Application Reference: 2026/92191

Proposal: Conversion and extension of existing agricultural barn to form single residential dwelling

Location: Land South of Common Lane, Denby Dale / Upper Denby, HD8 8YN

Subject: Formal Objection to Planning Application 2026/92191

Drawing Title.  
**PLANS & ELEVATIONS  
AS PROPOSED**

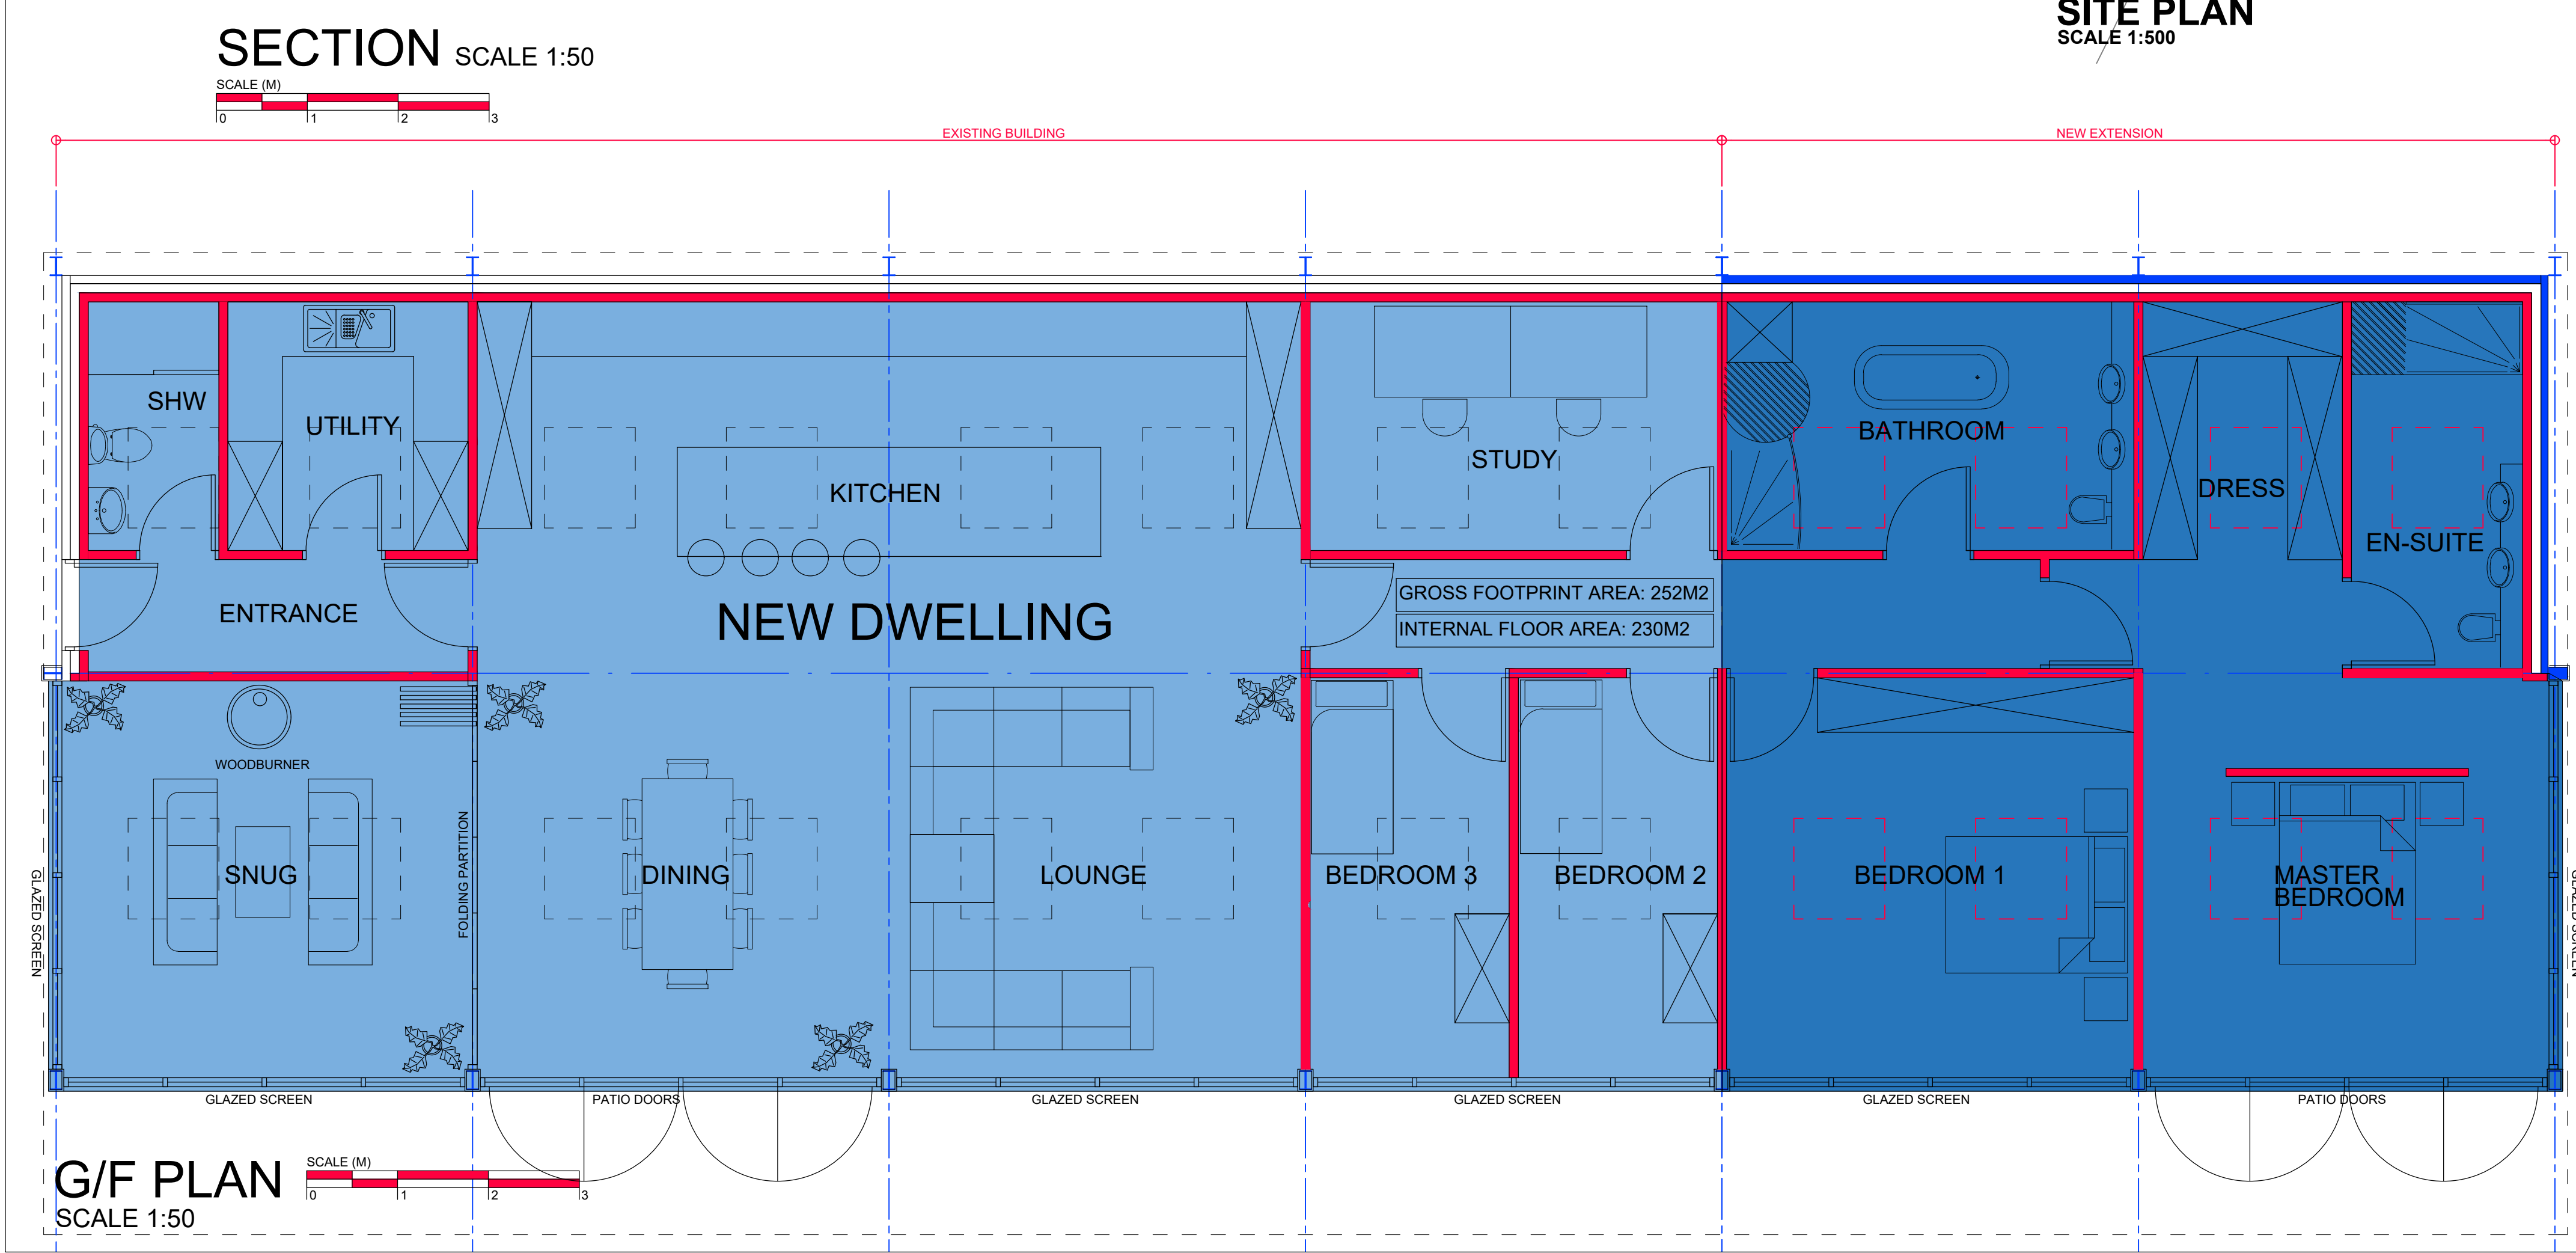
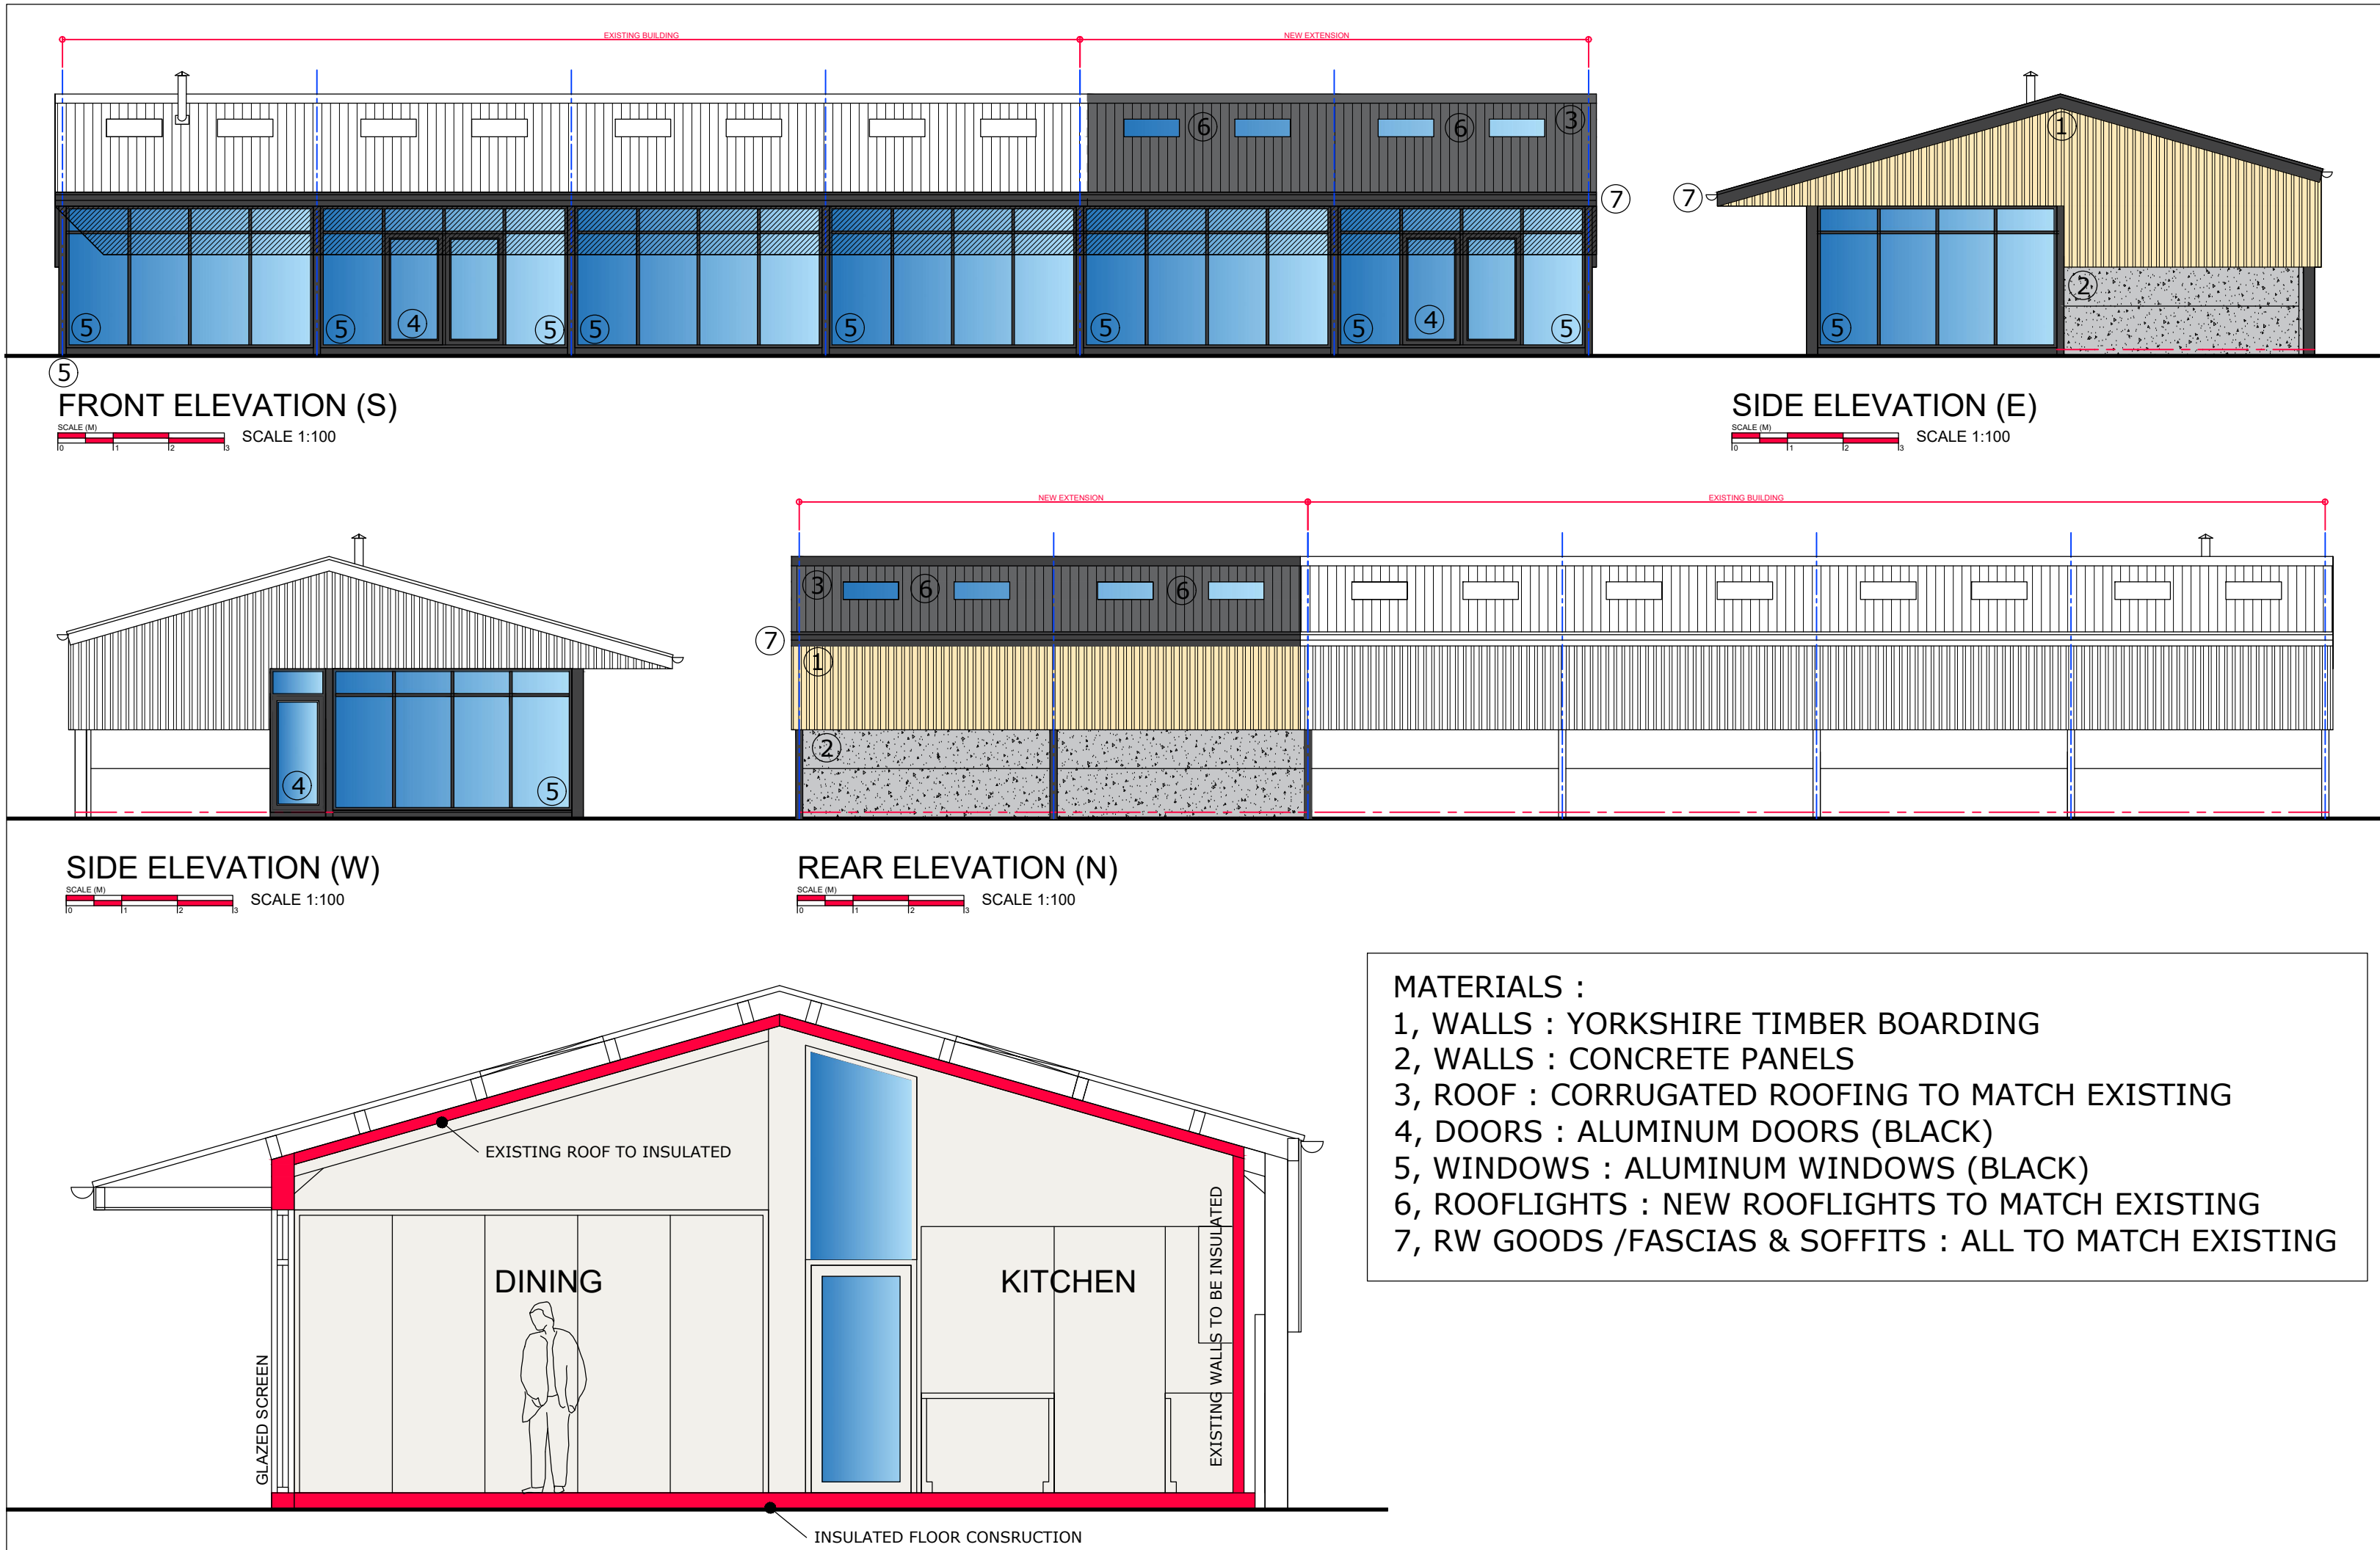
- **Disproportionate Additions:** The proposed residential extension fails the strict "disproportionate increase" test under national policy. The additions and alterations are materially larger than the original agricultural framework, resulting in a prominent, domestic footprint that harms the openness and character of the Green Belt.
- **Aesthetic and Character Creep:** The introduction of domestic curtilages, residential lighting, and structural extensions will drastically alter what is currently a rural, open landscape. This constitutes a clear, inappropriate creep into a sensitive Green Belt area between Upper Denby and Denby Dale.
